Consultation Response from KC,
Trees

2023/91922 65, The Cutting, Brockholes, Holmfirth, HD9 7HL

Alterations to rear ground floor opening, change of use of land to extend domestic garden, and erection of raised deck with store void below

Date Responded: 05/10/2023

Proposed Block Plan

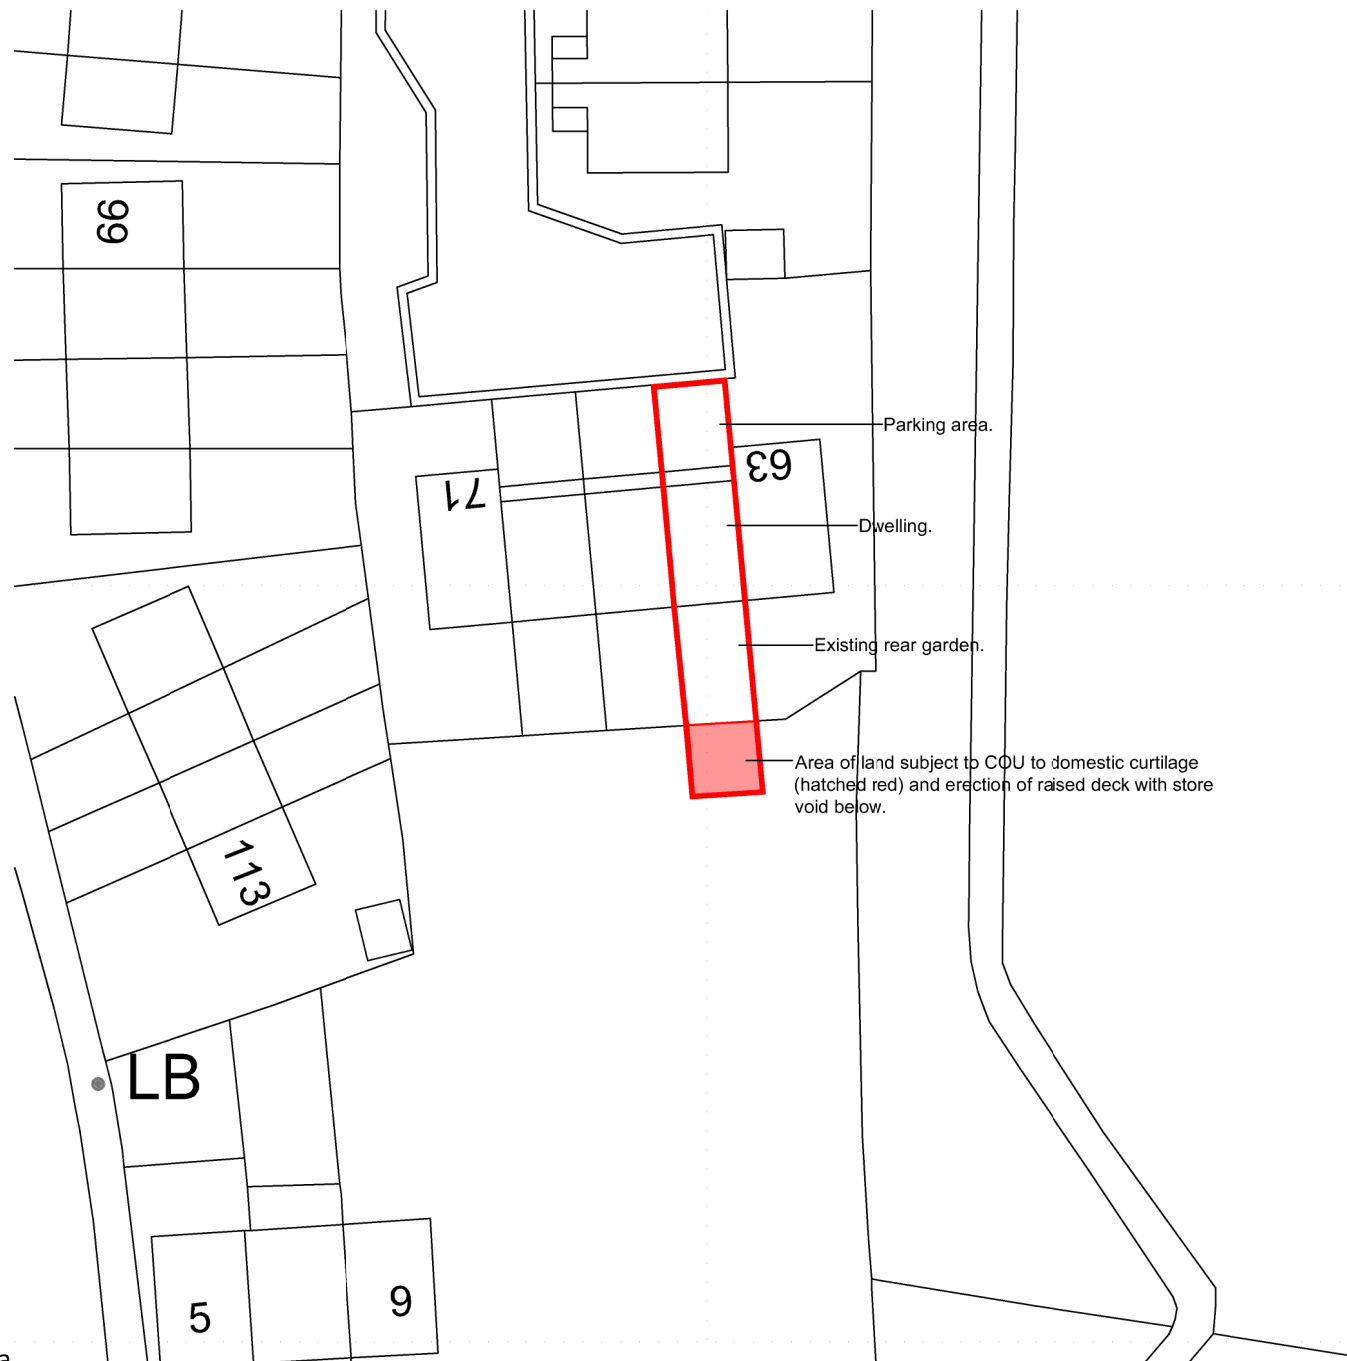
However, this proposal inevitably will create pressure to prune and/or remove the Sycamore trees overhanging the boundary and the proposed decking. Probably very quickly after the proposal is implemented.

The position of the decking under the current canopies of the trees now or at least it foreseeably being under the canopies of the trees because of future growth. This will result in pressure to prune or remove the trees to alleviate the nuisances perceived or otherwise.

Overall, from a trees perspective on principle there is an objection to the proposal. Because it will create pressure to prune or remove the trees overhanging the boundary for the reasons mentioned

above, conflicting with adopted Local Plan Policy LP33. However, if there isn't another planning reason to refuse the proposal, and the application is approved on planning balance please include conditions to require the use of micro-piles/screw as shown on drawing number 23/896/04b, facilitation tree pruning be agreed in writing with the local authority and an informative about the presence of the TPO.
